Date: 01-Feb-2024
Our Ref: 2023/93645

**TOWN AND COUNTRY PLANNING ACT 1990
TOWN AND COUNTRY PLANNING (GENERAL PERMITTED DEVELOPMENT)
(ENGLAND) ORDER 2015 (as amended), SCHEDULE 2, PART 3, PART MA
NOTIFICATION OF PROPOSED CHANGE OF USE CLASS MA – COMMERCIAL,
BUSINESS AND SERVICE USES TO DWELLINGHOUSES
APPLICATION NUMBER: 2023/93645
AT: 1st & 2nd floors, 9-13, Market Walk, Huddersfield, HD1 2QA**

Prior approval of proposed change of use of a building from commercial, business and service uses to dwellinghouses.

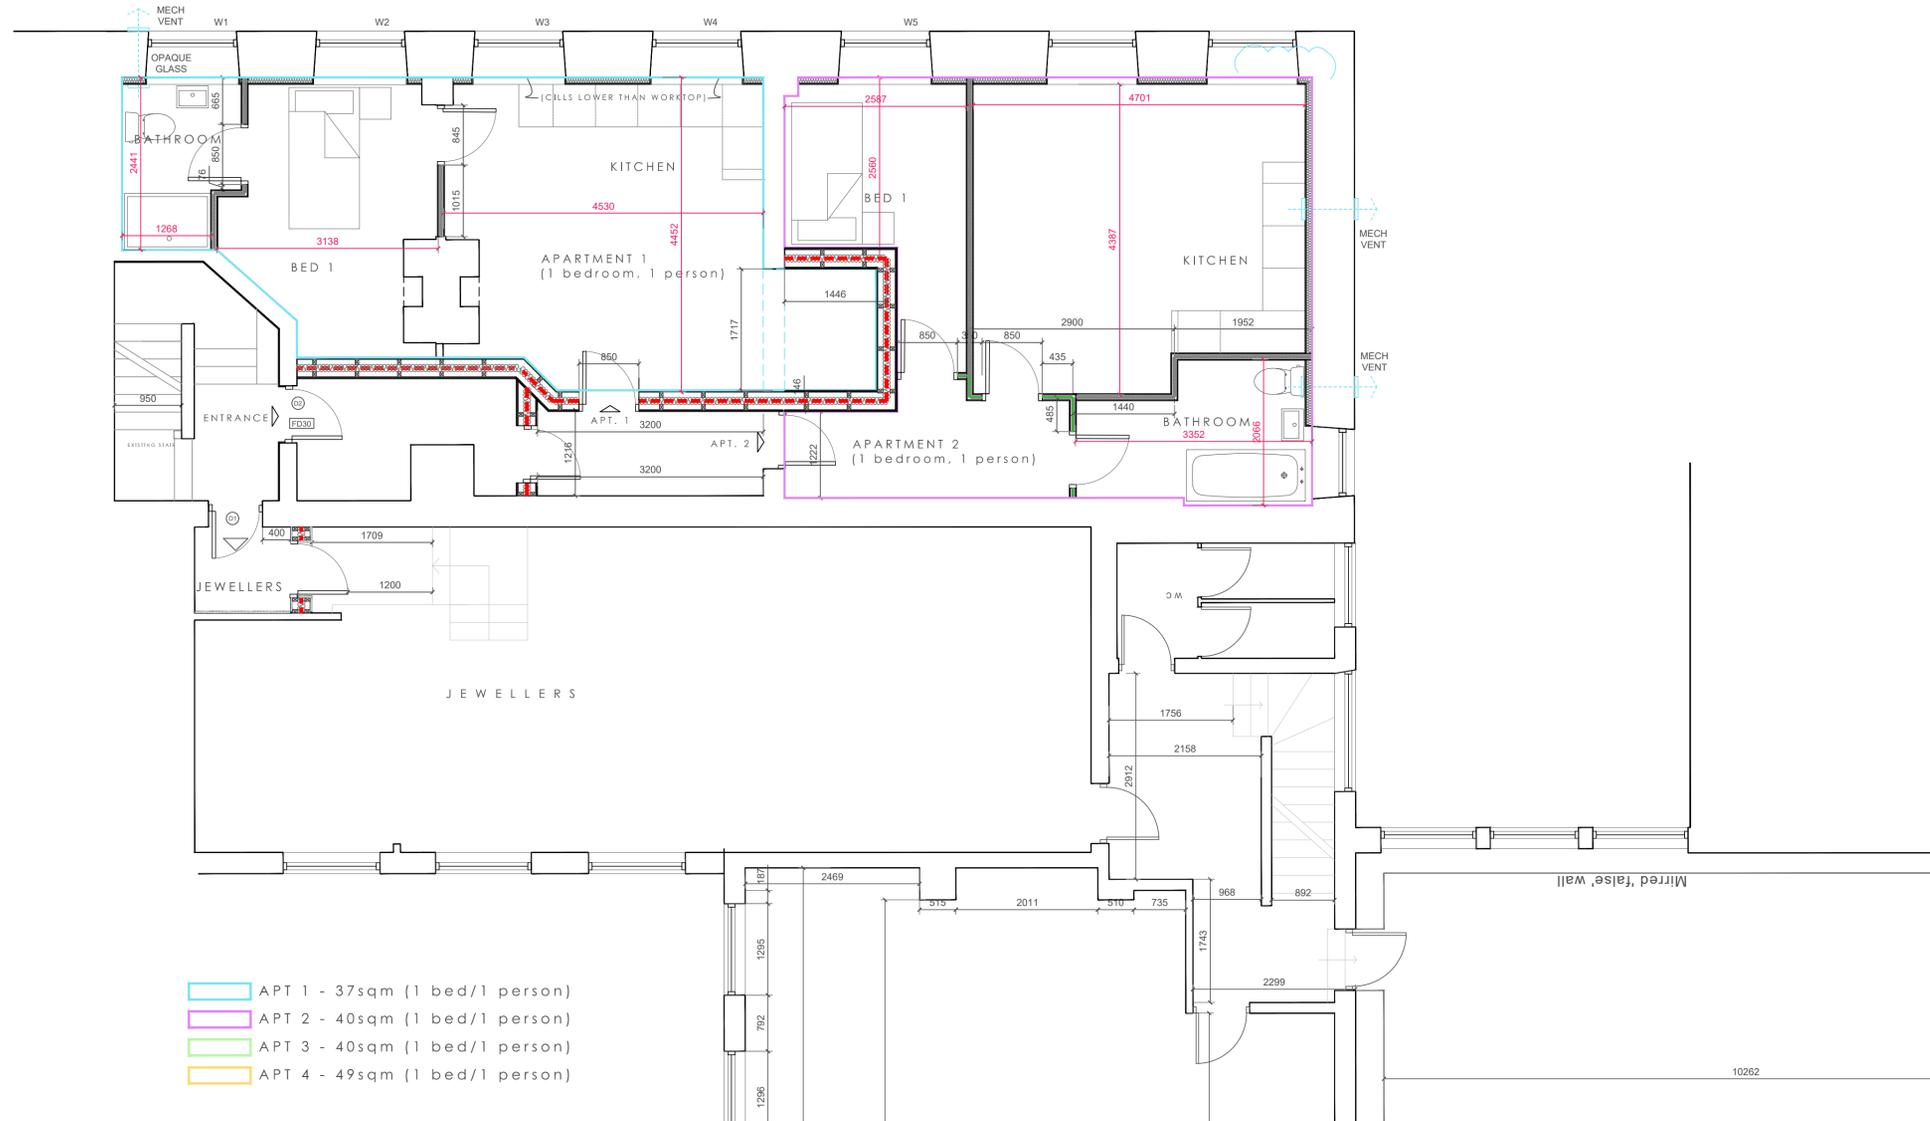
1. Notwithstanding the submitted details, Apartment 1 shall not be occupied by more than 1 no. person unless space standards for additional occupants as defined by the National Described Space Standards are achieved.

2. Notwithstanding the submitted details, Apartment 2 shall not be occupied by more than 1 no. person unless space standards for additional occupants as defined by the National Described Space Standards are achieved.

5. Before the development is first brought into use written evidence to demonstrate that the airborne sound insulation performance of the party floors/walls/ceiling of each apartment is a minimum of 55dB Dntw + Ctr shall be submitted to and approved in writing by the Local Planning Authority.
